CITY OF ALBUQUERQUE

September 6, 2019

**Re: Homewood Suites
5400 San Antonio Dr. NE
60-Day Temporary Certificate of Occupancy
Transportation Development Final Inspection
Engineer's/Architect's Stamp dated 4-11-18 (E18D050)
Certification dated 8-28-19**

SITE PLAN

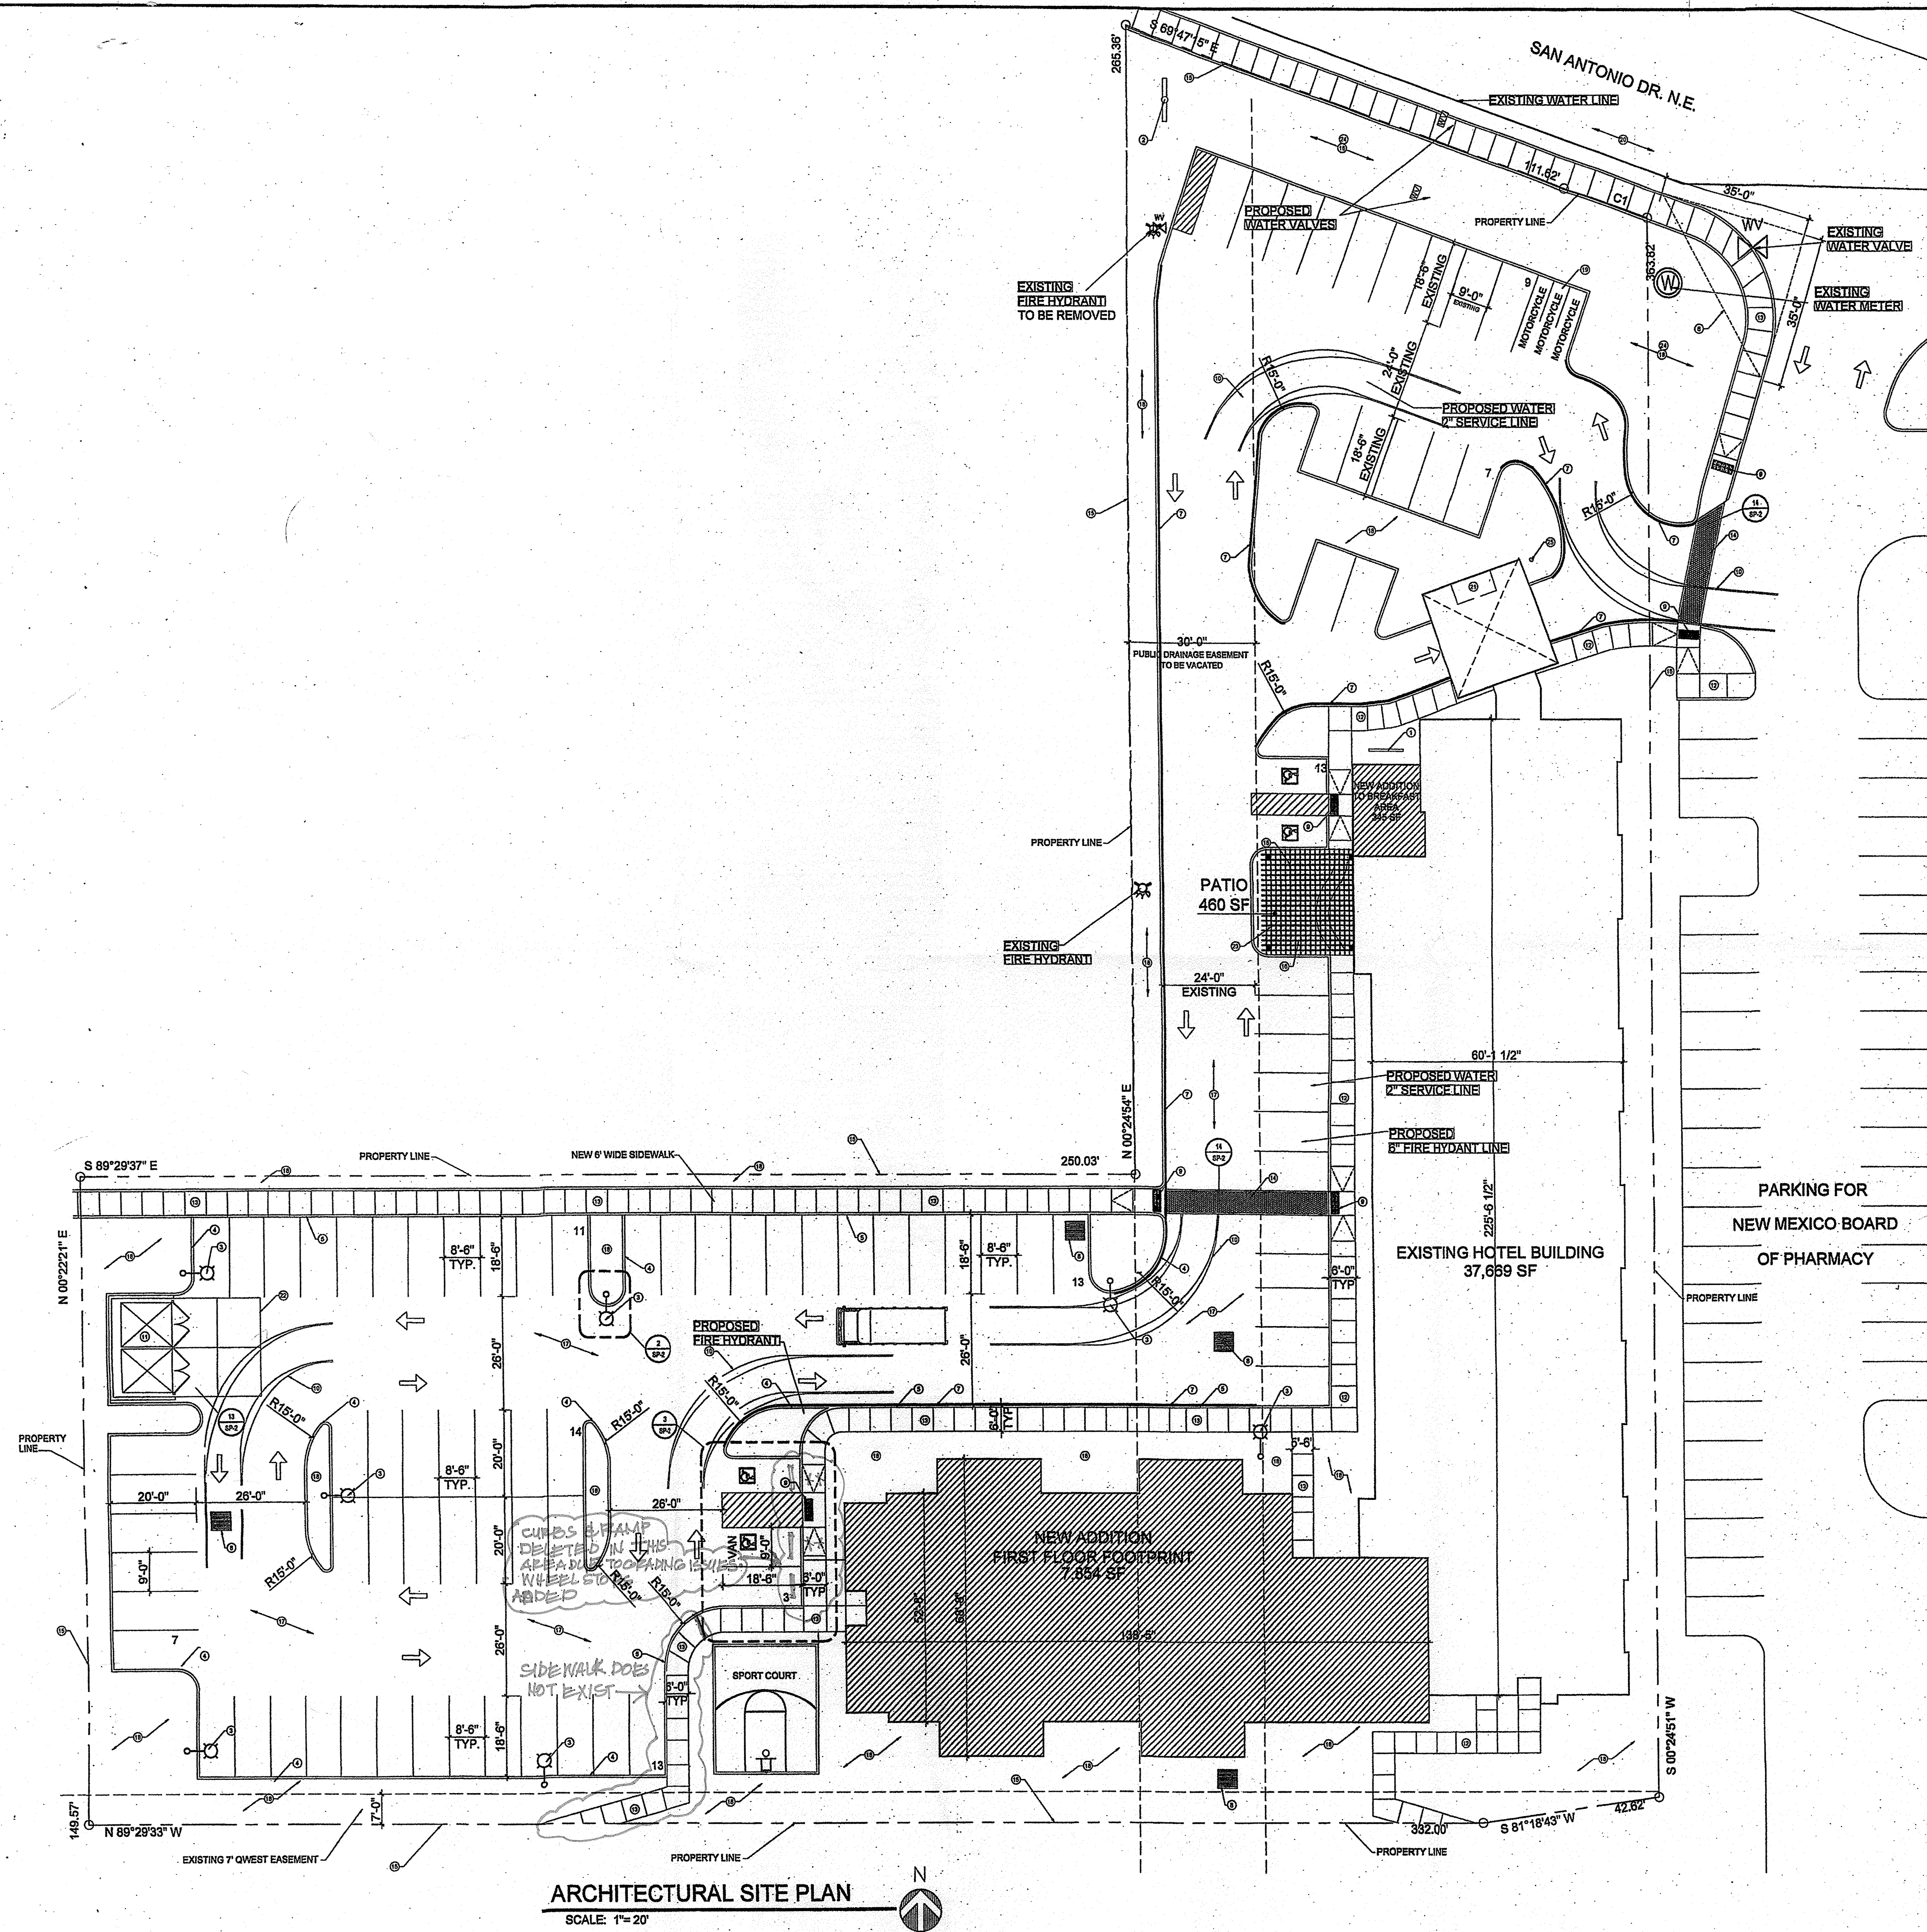
- Add sidewalk connecting to path along channel.

1. The approved and stamped Site Plan for Building Permit with changes drawn in red.
2. Transportation Certification letter on either the plan or applicants letterhead.
3. A Drainage Transportation Information Sheet (DTIS)
4. Send an electronic copy of your submittal to PLNDRS@cabq.gov.
5. The \$75 re-submittal fee.
